Comments related to planning application number 2020/62/91838/W

Proposed front elevation (1:100)

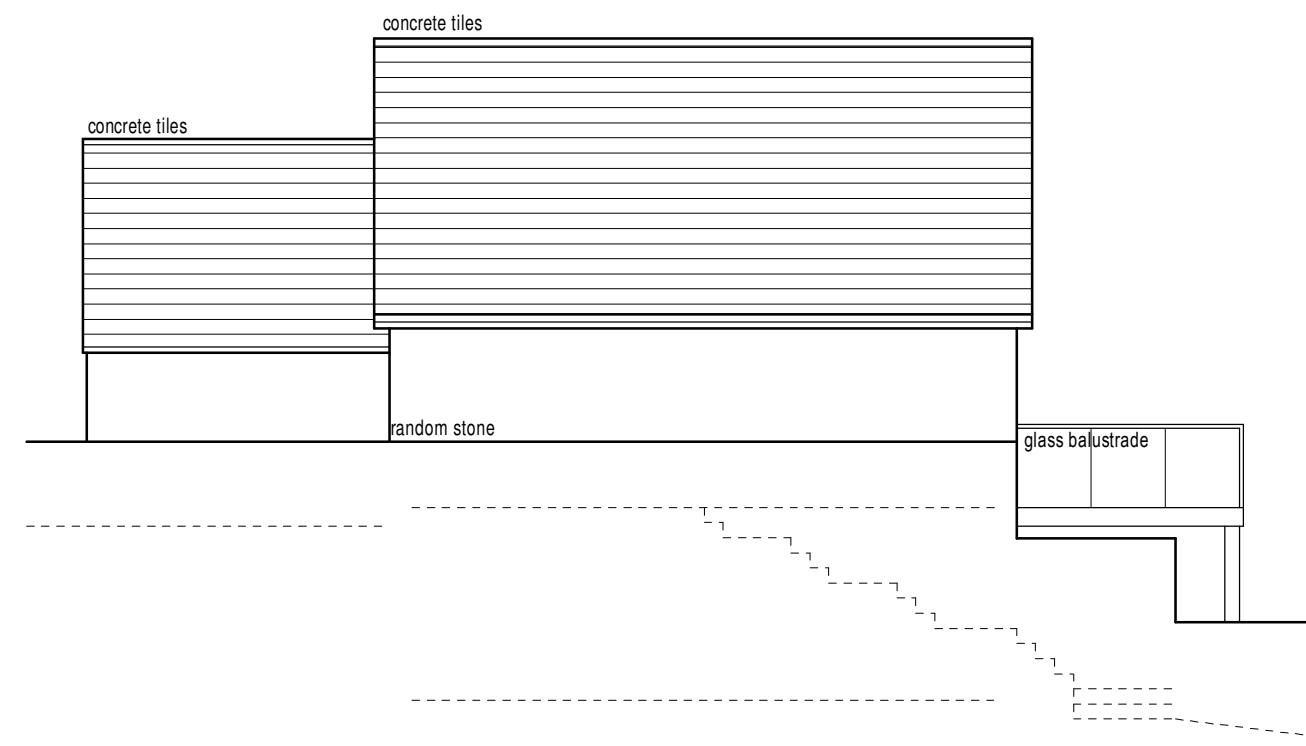
The proposed terrace support posts have a side that faces the front elevation, and an opposite side that faces the highway. You might expect, measuring the shortest distance from the front elevation wall, to each of the support post faces, would provide the same result, when using the different proposed drawings. However, they don't.

Elevation	Inner face
Front	552.04cm
First floor	563.45cm
Site plan	509.69cm

Proposed side elevation (1:100)

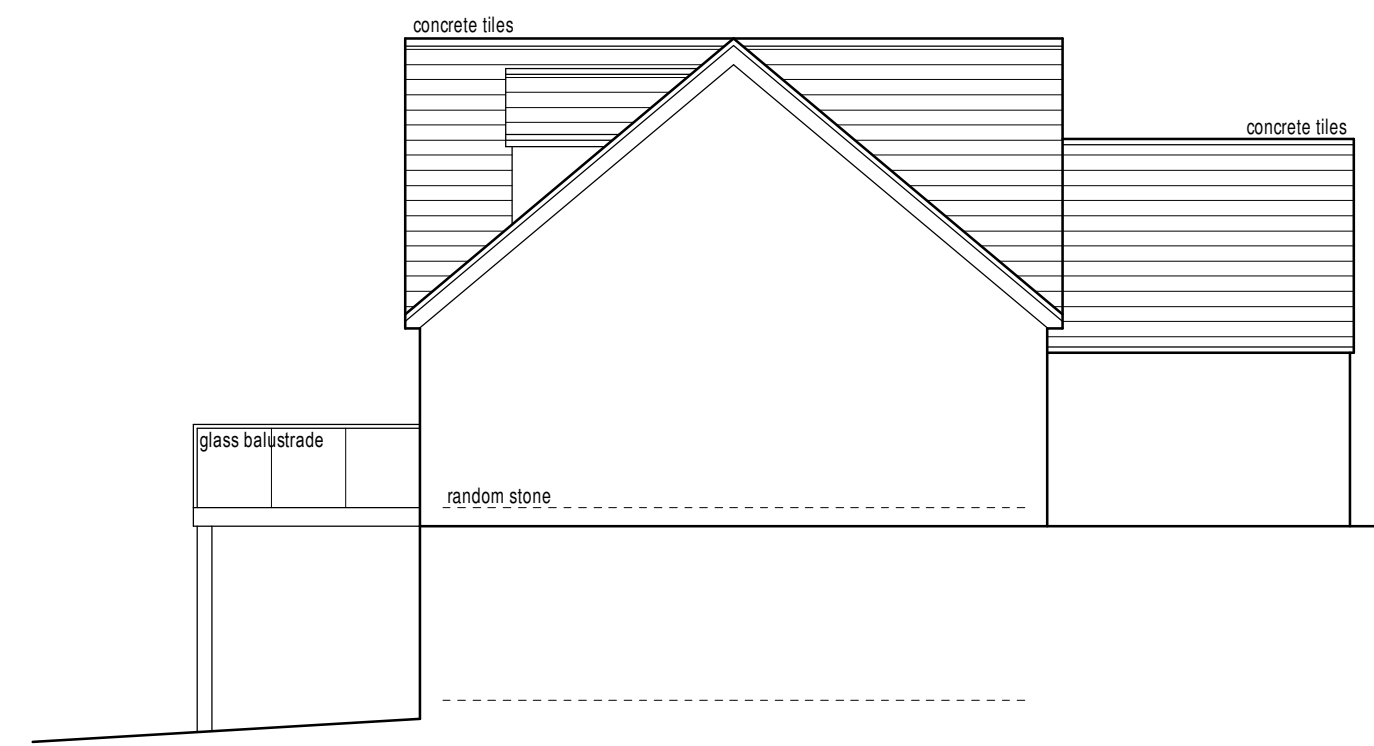
The height, to the top of the balustrade, on the side of no.92 is proposed to be 110cm. This is 40cm lower than on the side of no.88. The glass is proposed to be clear, on the side of no.92. The glass is proposed to be opaque, on the side of no.88. The opaque glass, on the side of no.88, is proposed to cover the whole side of the proposed terrace. Over half of the opening, on the side of no.92, is proposed to be completely exposed.

Proposed ground floor layout (1:100)

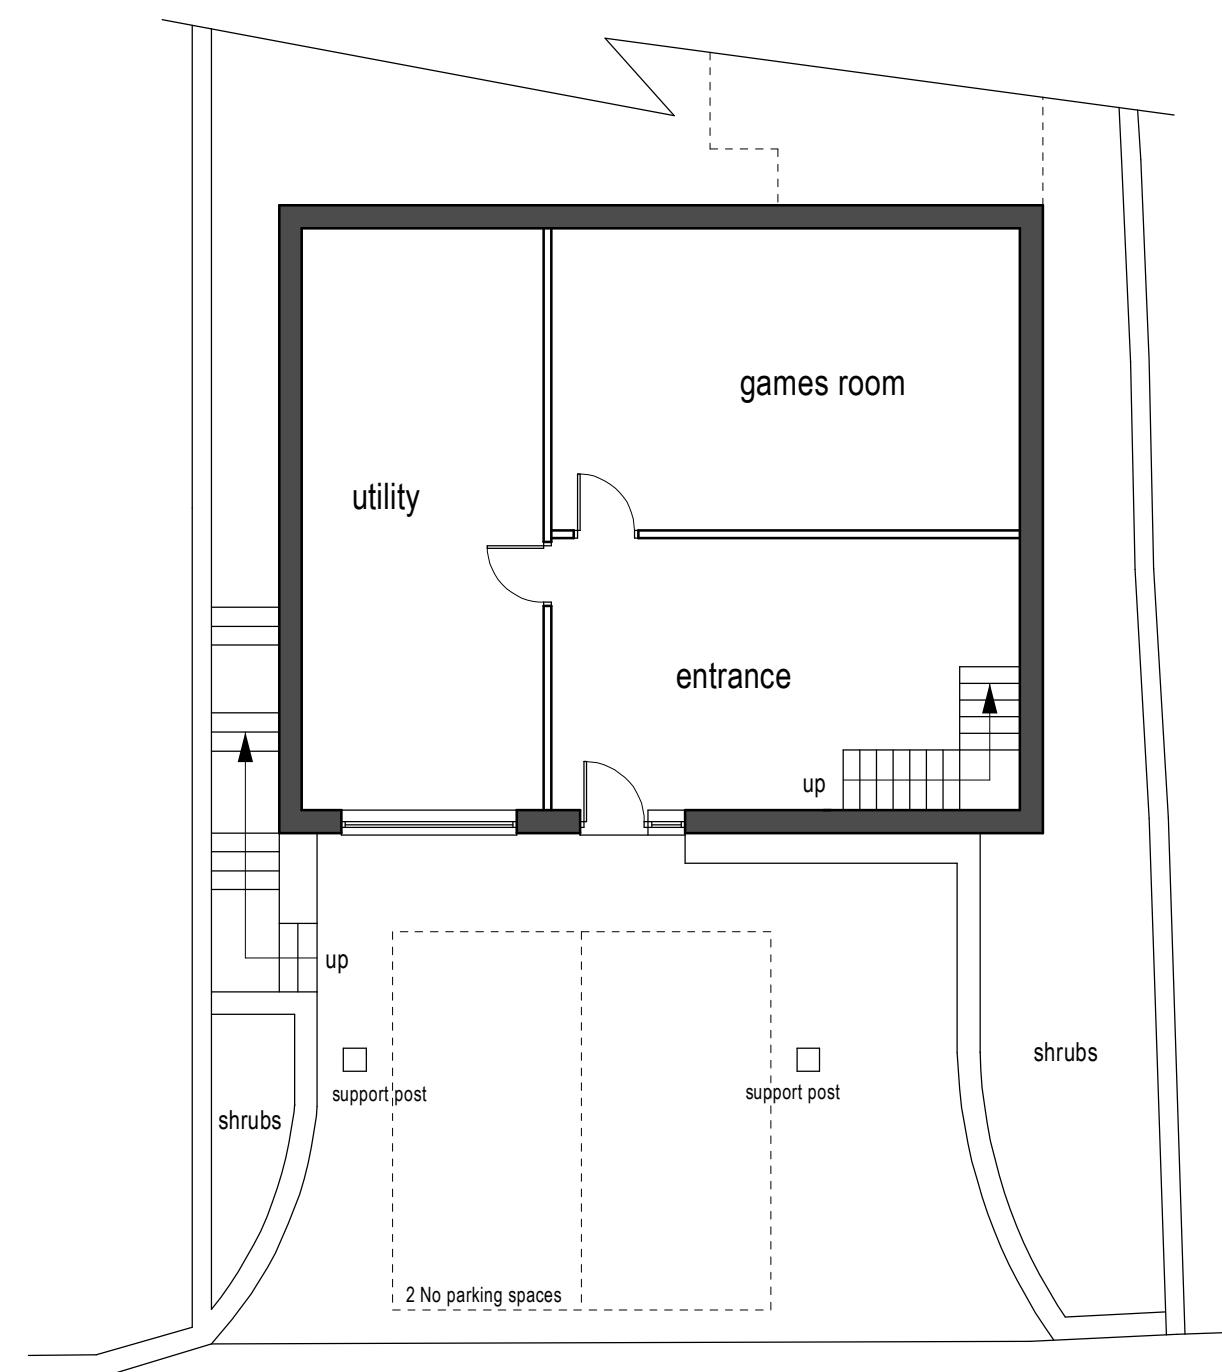
As such, the current applicant's plan is incorrect, if it omits the wall structure as it is. But, not only that. The main concern raised, by this omission, for me, relates to underpinning.

Site plan (1:200)

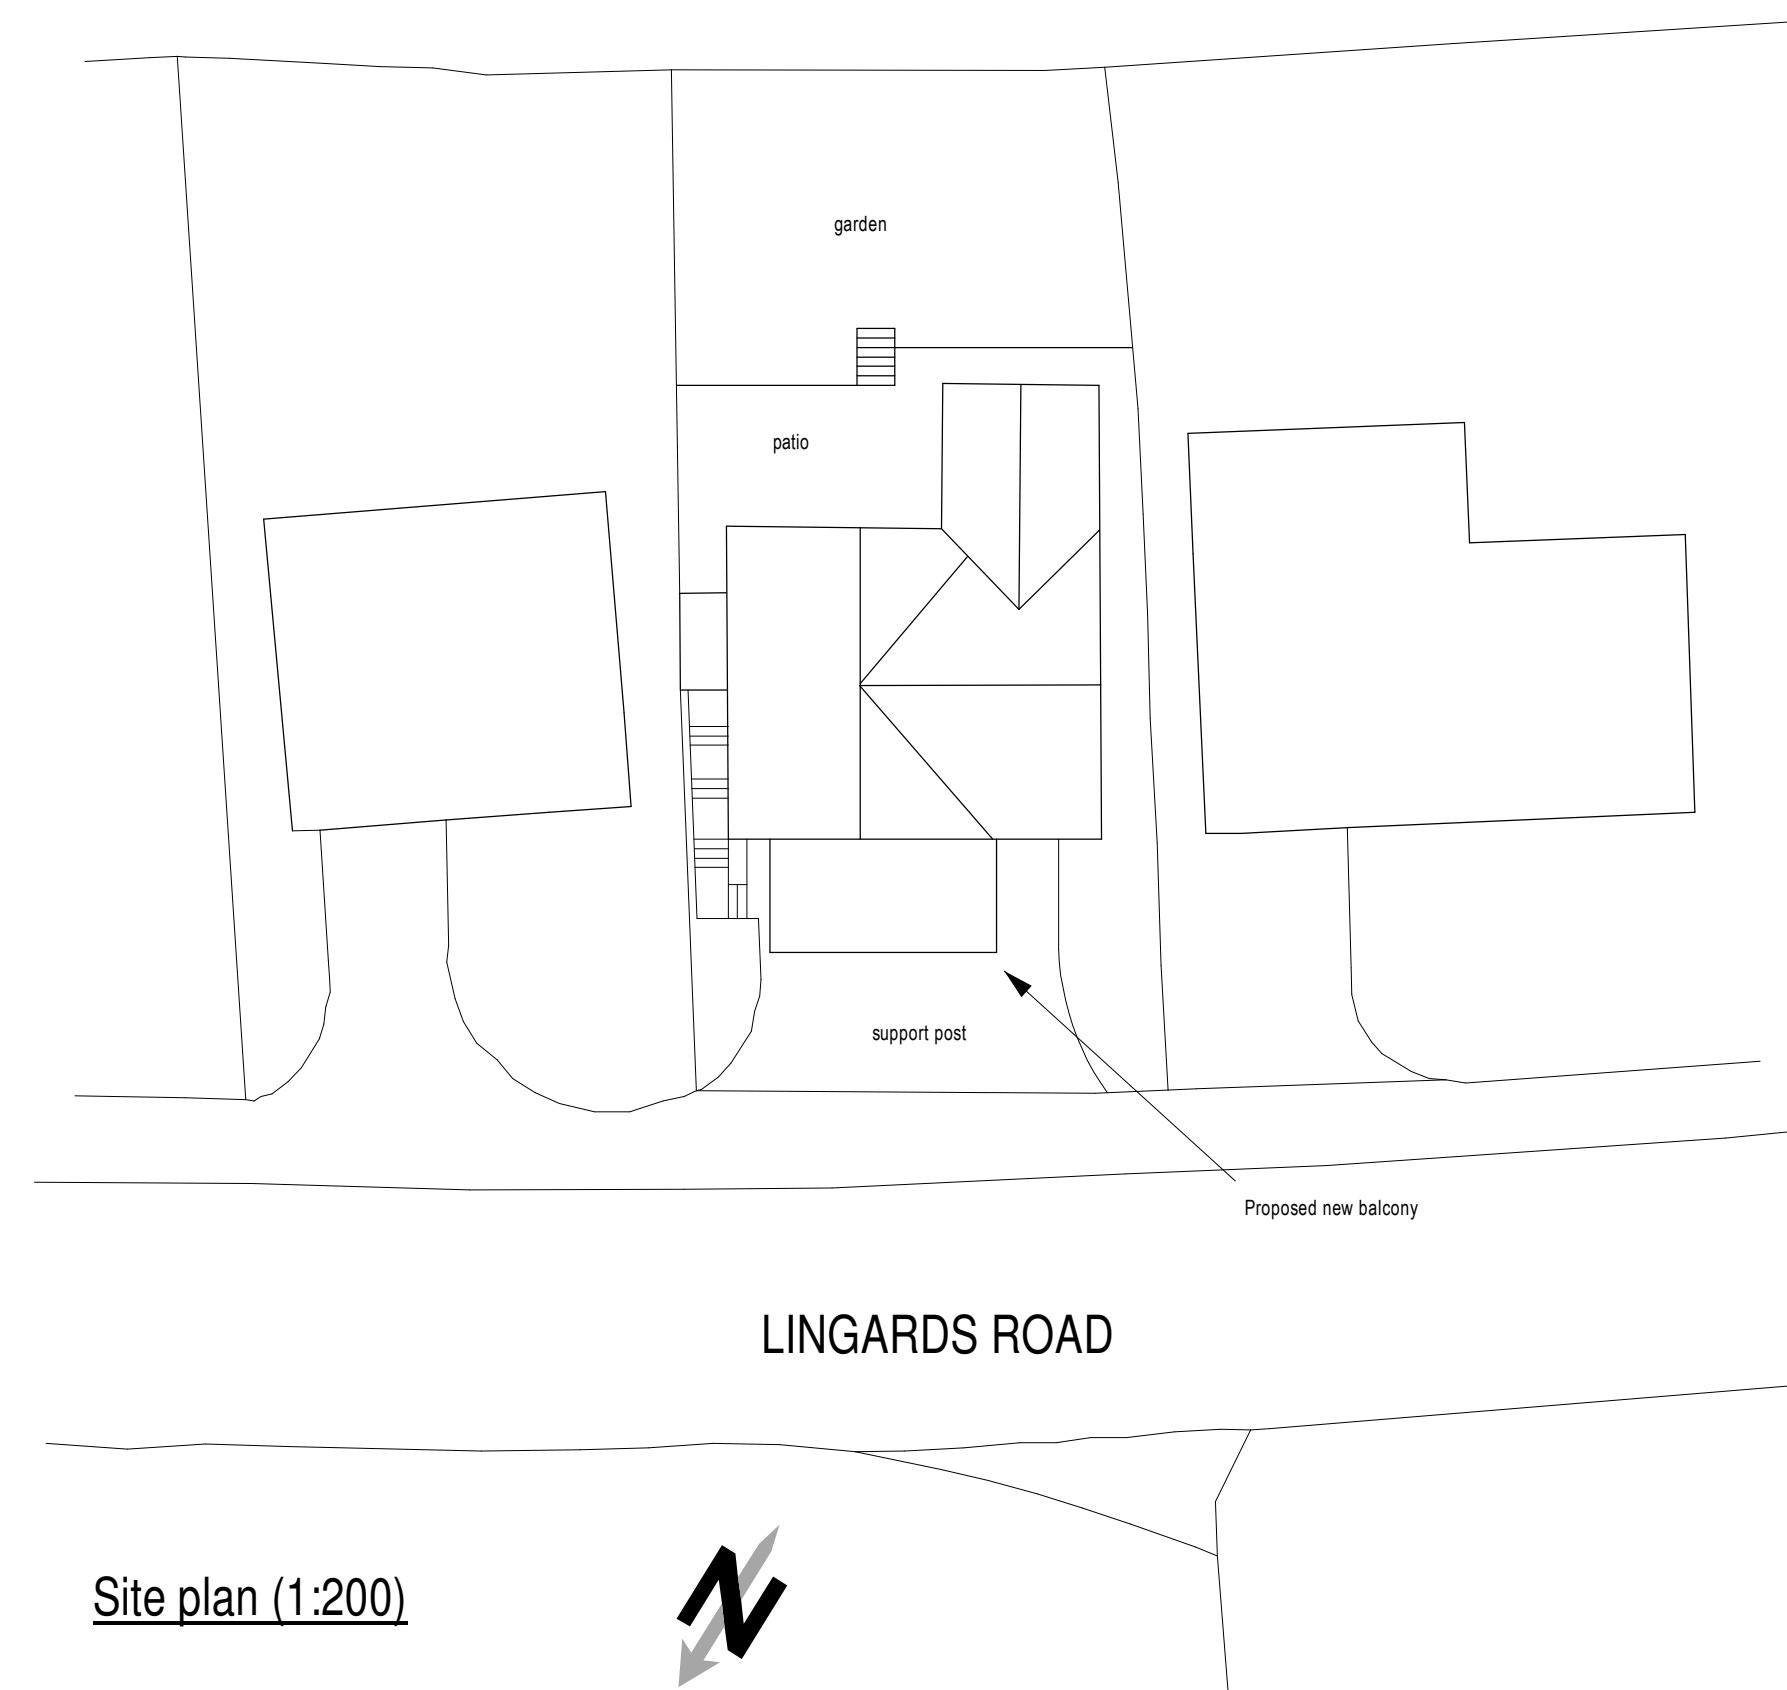
The boundary, seen on the site plan, has been drawn in the wrong place. The actual boundary follows the physical boundary wall that runs parallel to no.90. This wall was erected when the property was originally built.

Using the submitted plans as a guide, the blue line, on the image below, shows where the boundary is suggested to fall, which is across the driveway of no.92. The red line depicts an approximation of where the actual boundary falls. There is a marked difference between the two.

- I. Completion of this section of the form does not follow the guidance concerning accuracy, as it is inaccurate. The boundary is shown in the wrong place. The impact of this is the submitted plans would cross onto property belonging to no.92. It does not all belong to no.90 as stated.
- II. The loss or effect on the trees cannot be carried out without the owner's permission. For the reasons stated above, no such permission is proposed.
- III. If moving the wall, closer to the trees, were possible, the trees could become unstable, and topple or significantly move. This could endanger or damage the trees and cause them to die. An arboriculturalist would be required, to offer advice, to ensure the trees are properly protected.
